From: Craig Hill <chill@wright-ryan.com>
To: Jean Fraser <JF@portlandmaine.gov>
CC: "Jim Dunn(j.dunn@grondinconstruction.com)" <j.dunn@grondinconstruction.c...>
Date: 2/28/2014 12:21 PM
Subject: RE: 79 Walnut Street Site Access

I suggest you prepare an "amended Construction Management Plan" to be submitted to me - I will have Planning, DPS, Inspections and Traffic review and approve it prior to the start of any work on the site. I also will ensure that the Director of Planning, and the Development Review Services Manager, and the Director of Inspections are part of the review given the unusual nature of this development and the scale of public concern during the review.

The amended CMP should include:

Amended Construction Management Plan

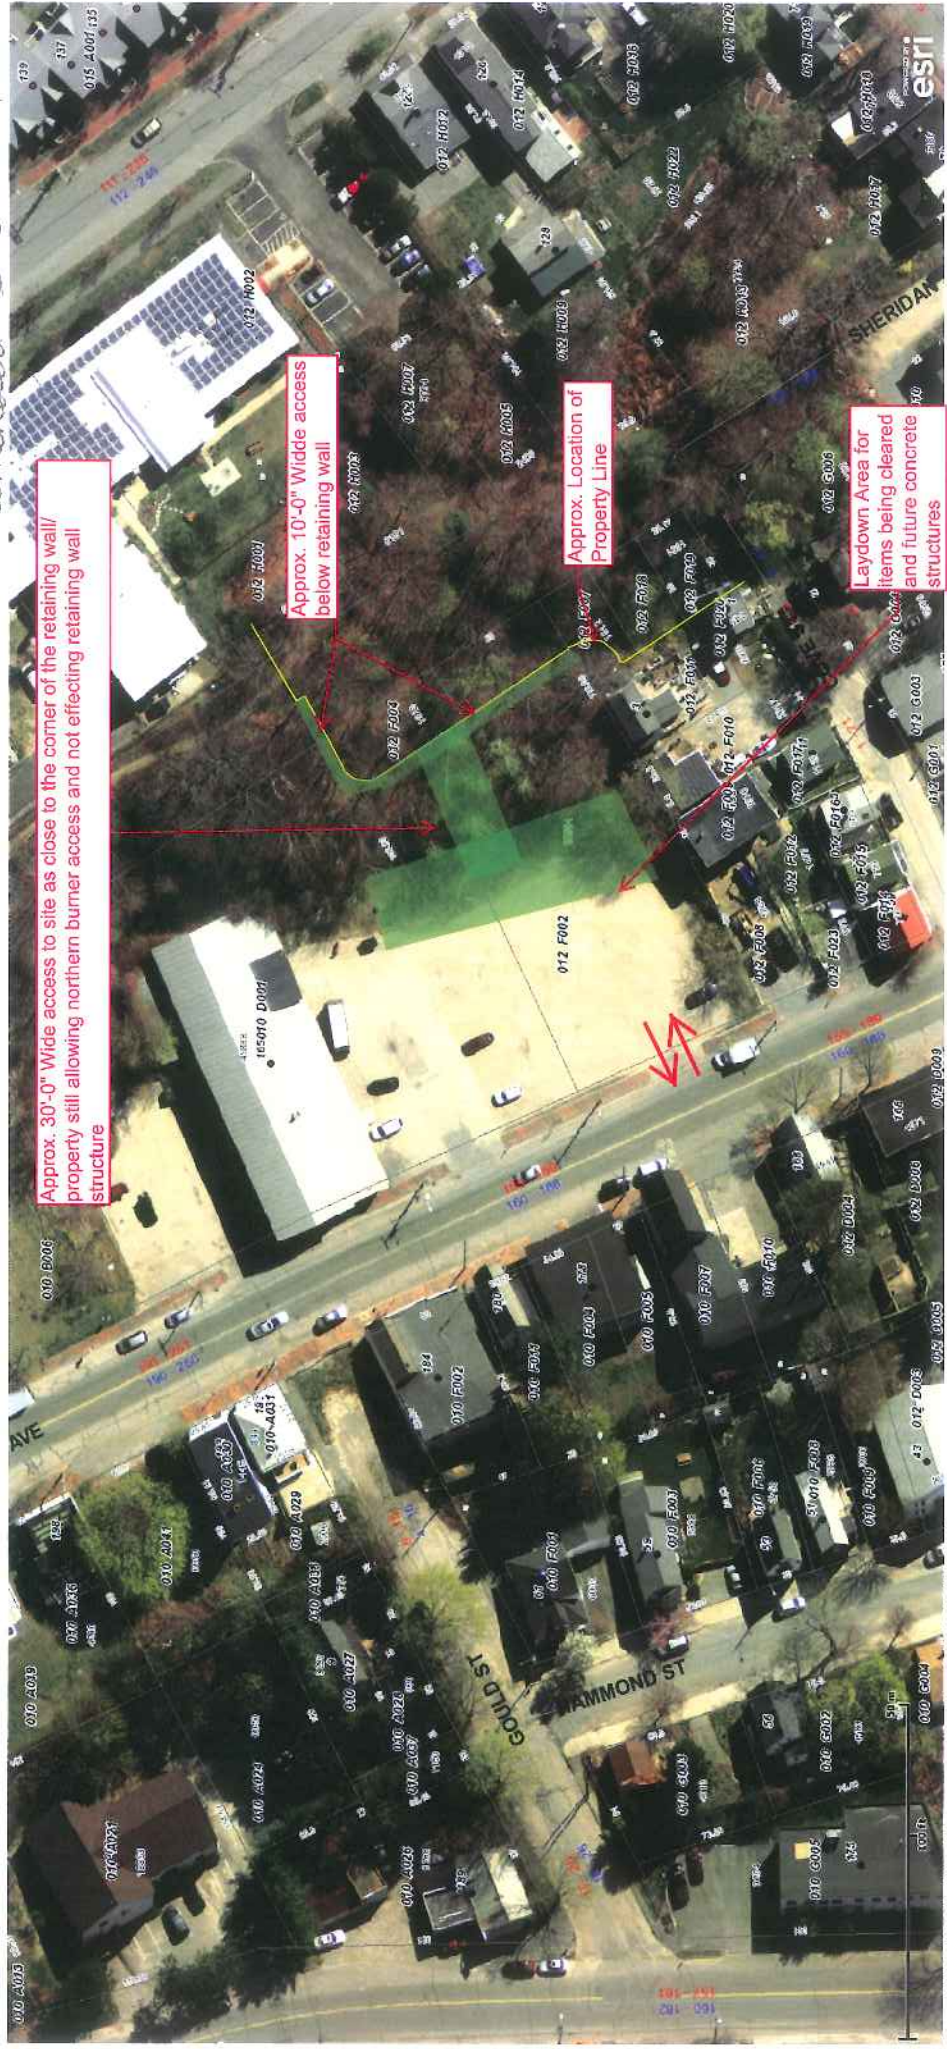
traffic- and the introduction of truck traffic on an arterial means that my traffic colleagues may want to look closely at this and more info is needed re the new access. Its proximity to dwellings is the other concern, as we discussed.

Could you put a note on the plan that states that the underlying proposals are not as approved (or something like "See the final plan set circulated Feb 2014 for final details of the proposals" and that only the construction info is up to date).

- * Phasing plan of some sort with timetables
- * What notifications to neighbors will be given
- * Each construction access point and the period of time months, and what days/times, it will be used
- * Timings for utility work in ROW and any changes to ROW details and impacts on traffic (and how managed)
- * For the Waterhouse site, show:
 - * exact location of the staging area and the truck access and routing
 - * what fencing and other steps will be taken to minimize impacts on the nearby residential properties- please locate the main activity area as far from properties on East Cove Street as possible
 - * show sightlines onto Washington Ave are safe (as speeds and traffic levels are much higher than Walnut) and sidewalk not impacted

- * show that erosion control measures will be in place, along with cleaning of truck wheels and dust management
- * for the Waterhouse site have a separate plan that shows the reinstatement of trees and vegetation, especially screening with neighbors and screening of the proposed development
- * for the Walnut St access, show:
 - * where safe routing for pedestrians will be located and what warnings will be in place (this is a school walking route I understand)
 - * any changes in on street parking arrangements
 - * any proposed traffic detours
 - * truck routes to the site access
- * show that erosion control measures will be in place, along with cleaning of truck wheels and dust management
- * indicate what steps being taken to minimize impacts on neighbors and their use of Walnut and Sheridan for access

I assume that you are preparing a Construction Traffic Management Plan and one of the issues is the safety of children getting to East End School - just please bear that in mind.
